**cPort Credit Union 50 India St., BP# 2017-01518**

Below are my responses per our conversation yesterday.

J8 TELLER POD FRONT ELEVATION
1/2" = 1'-0"

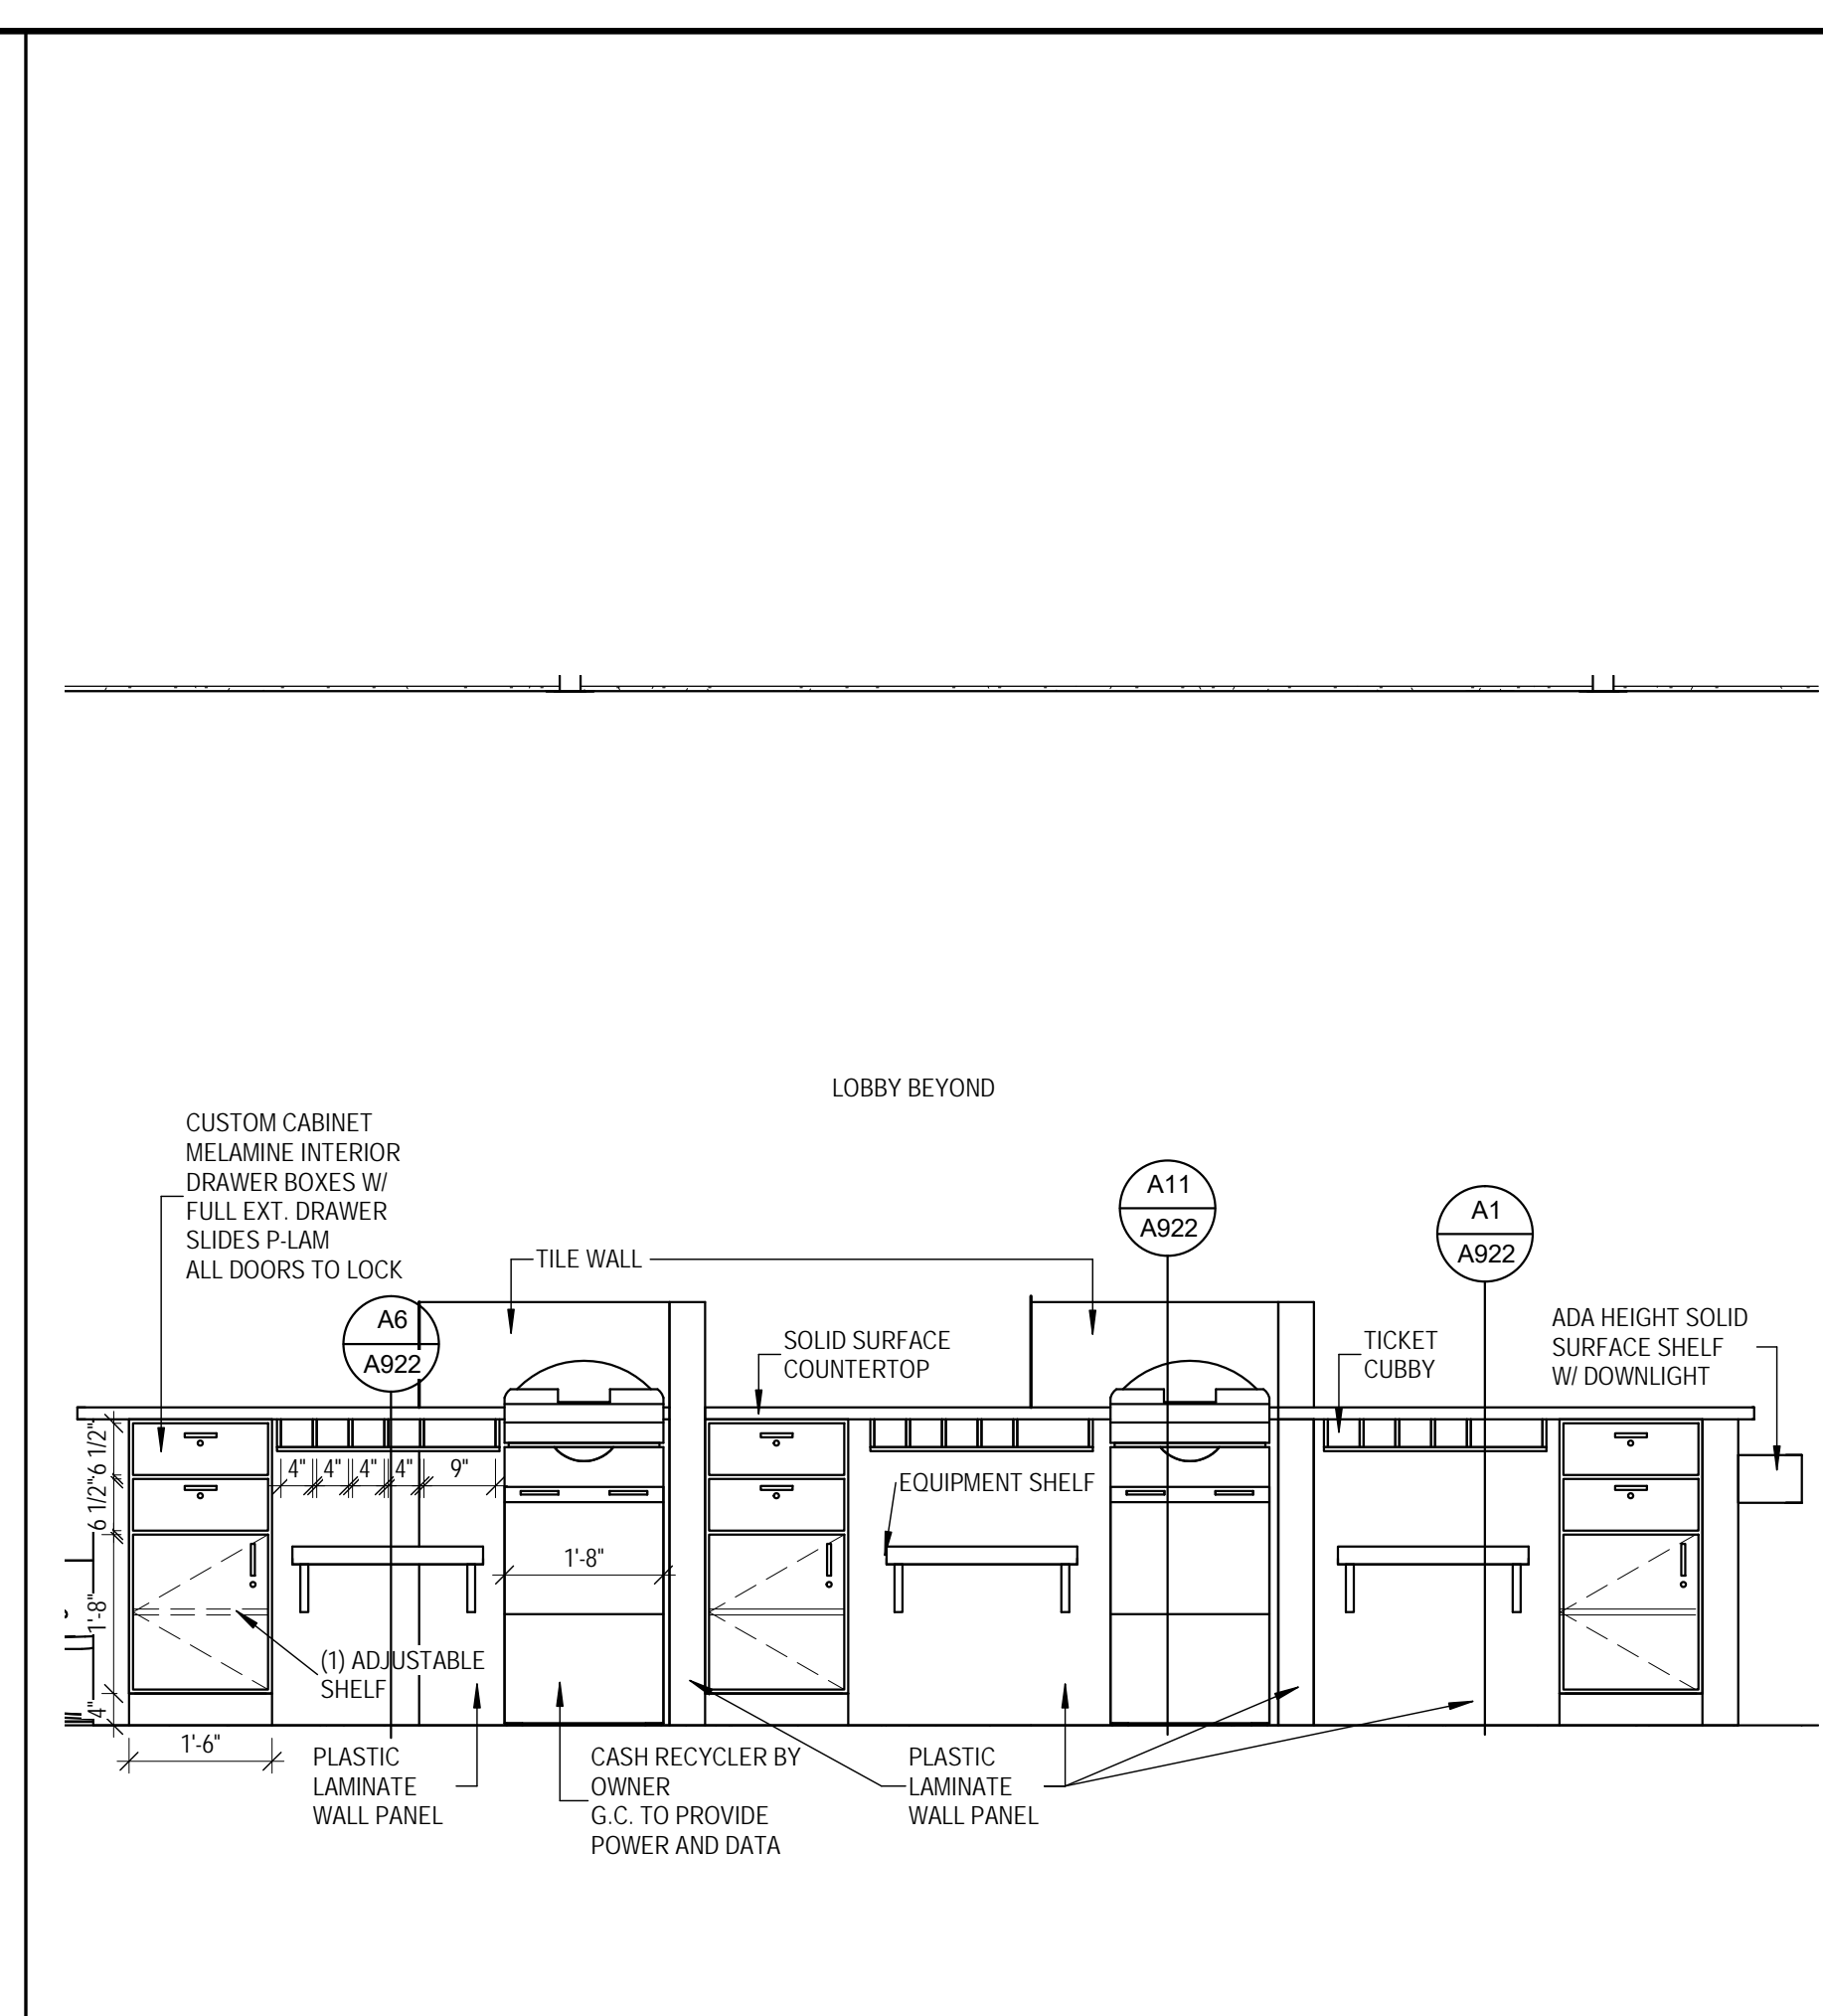
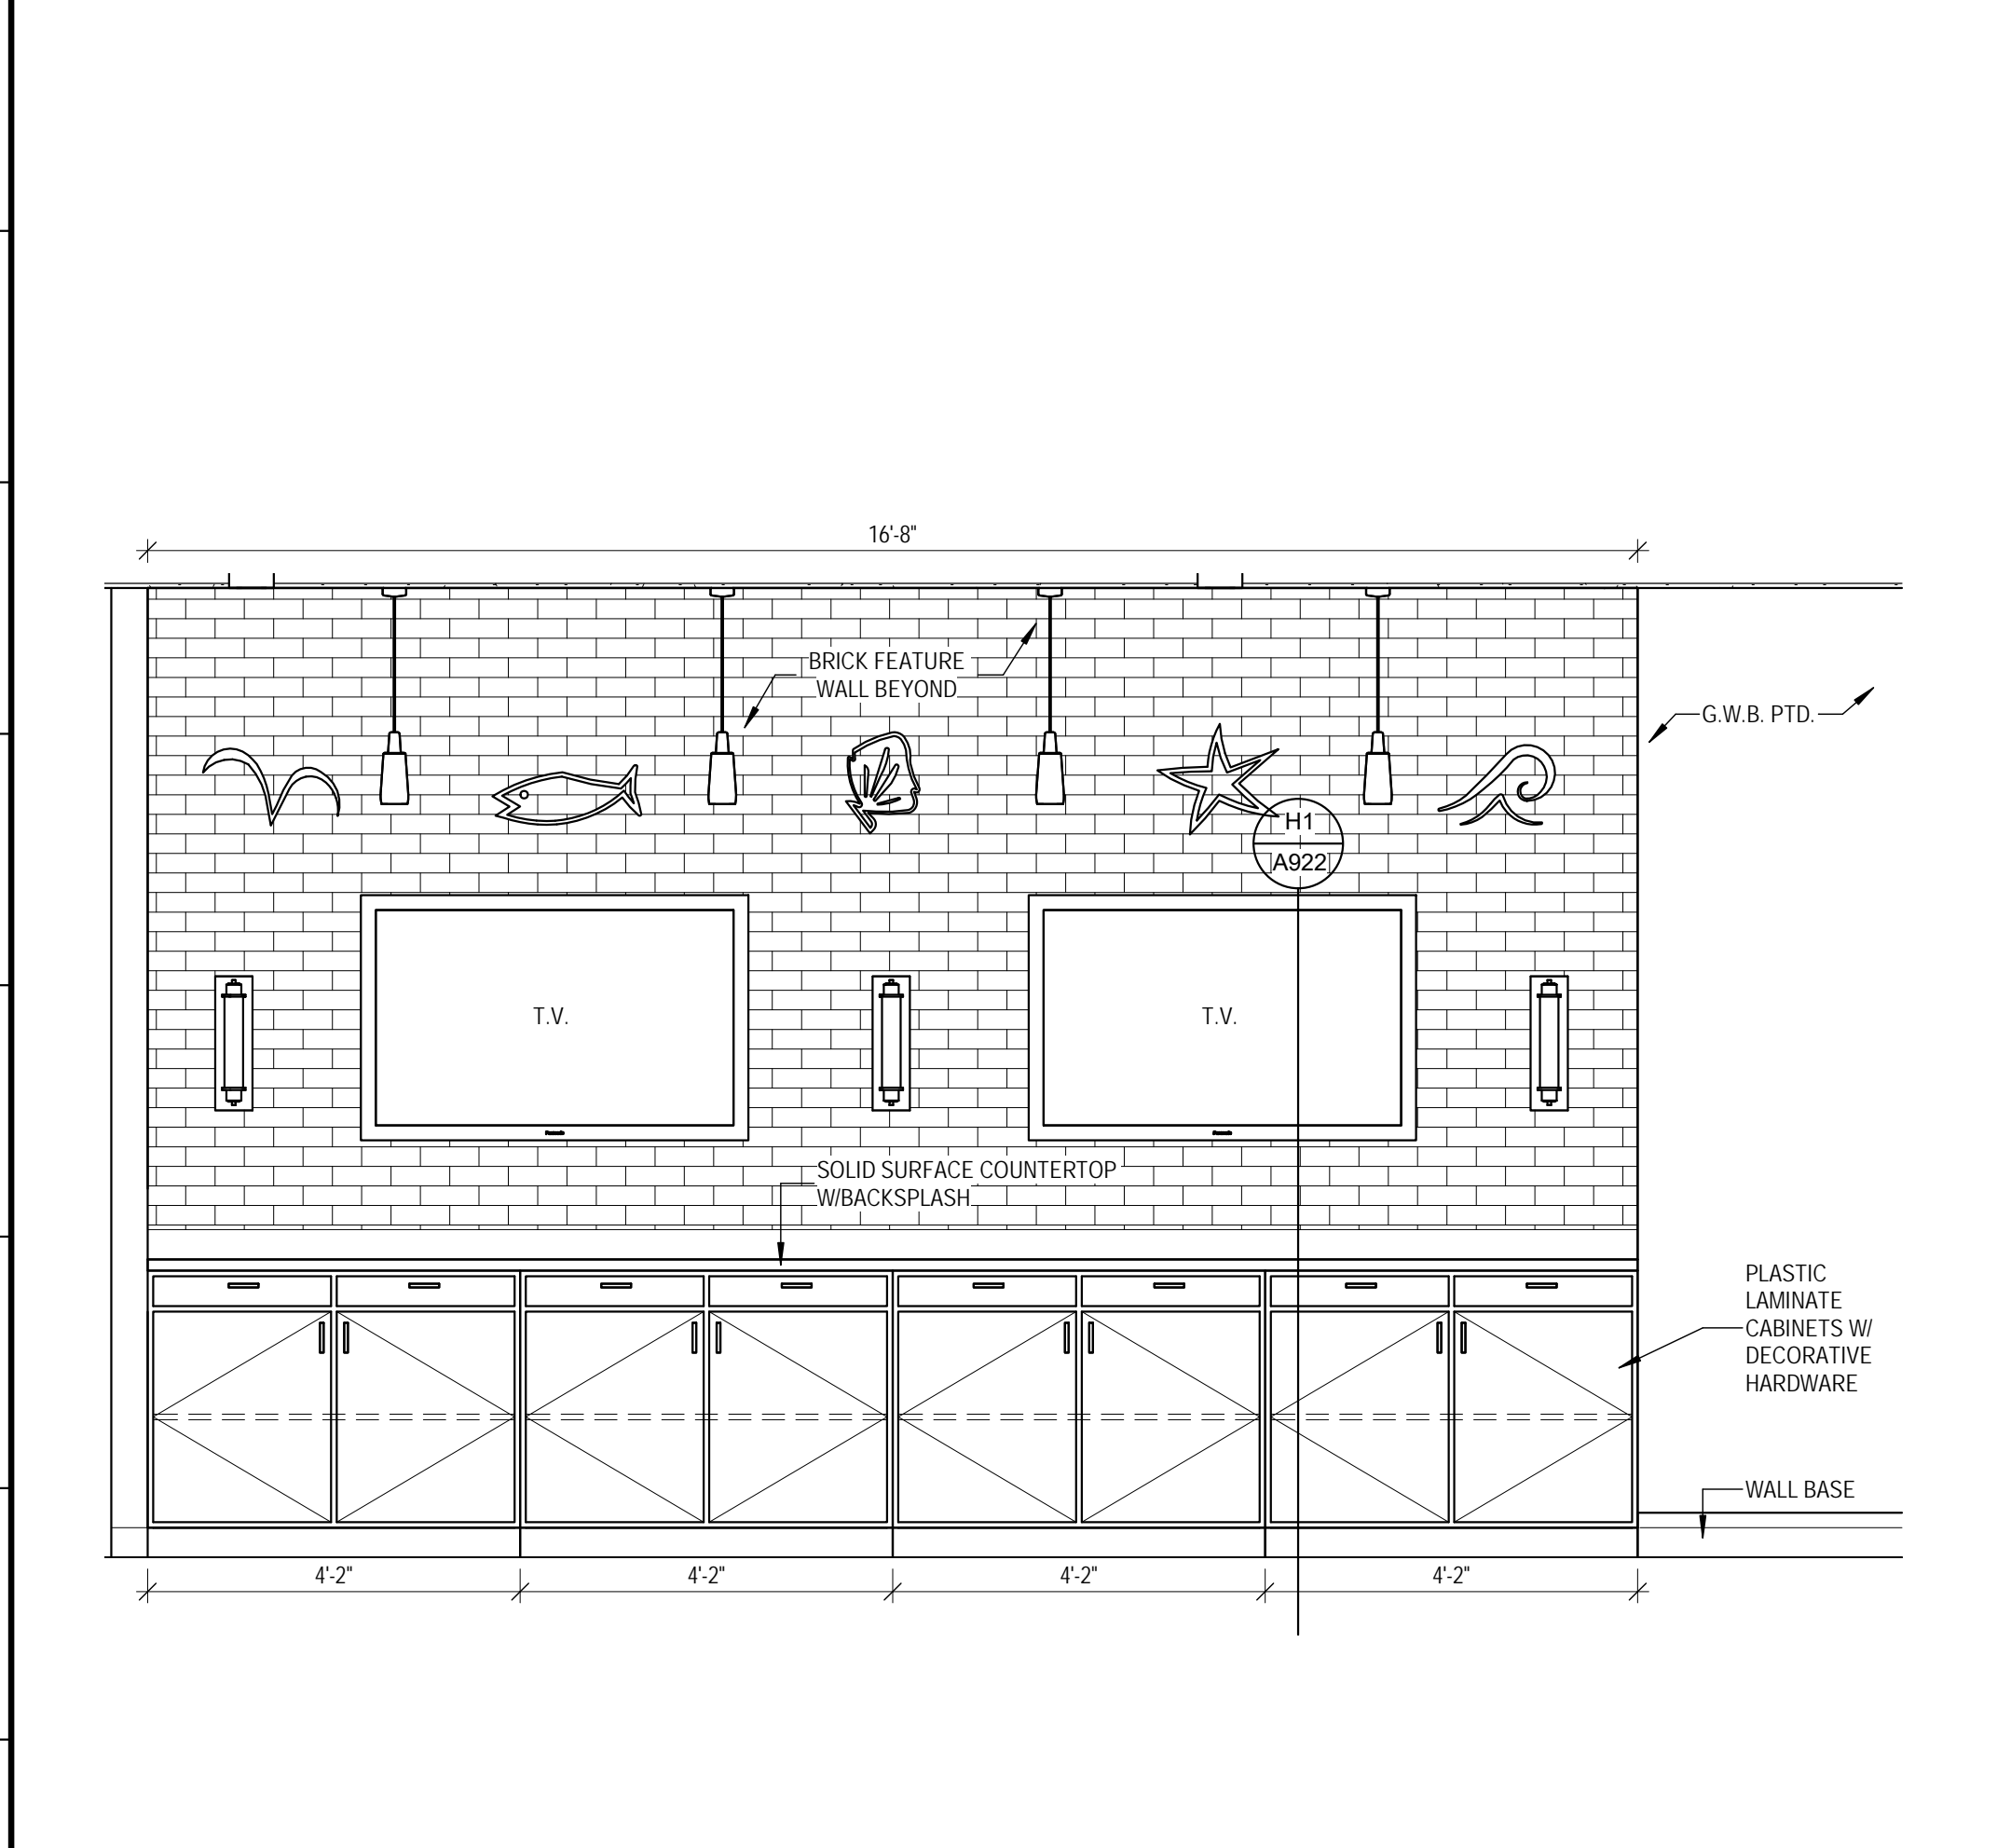
6. Sheet A920 – Counter height was modified at the coffee station and an additional trash receptacle was added below the counter. See attached pdf
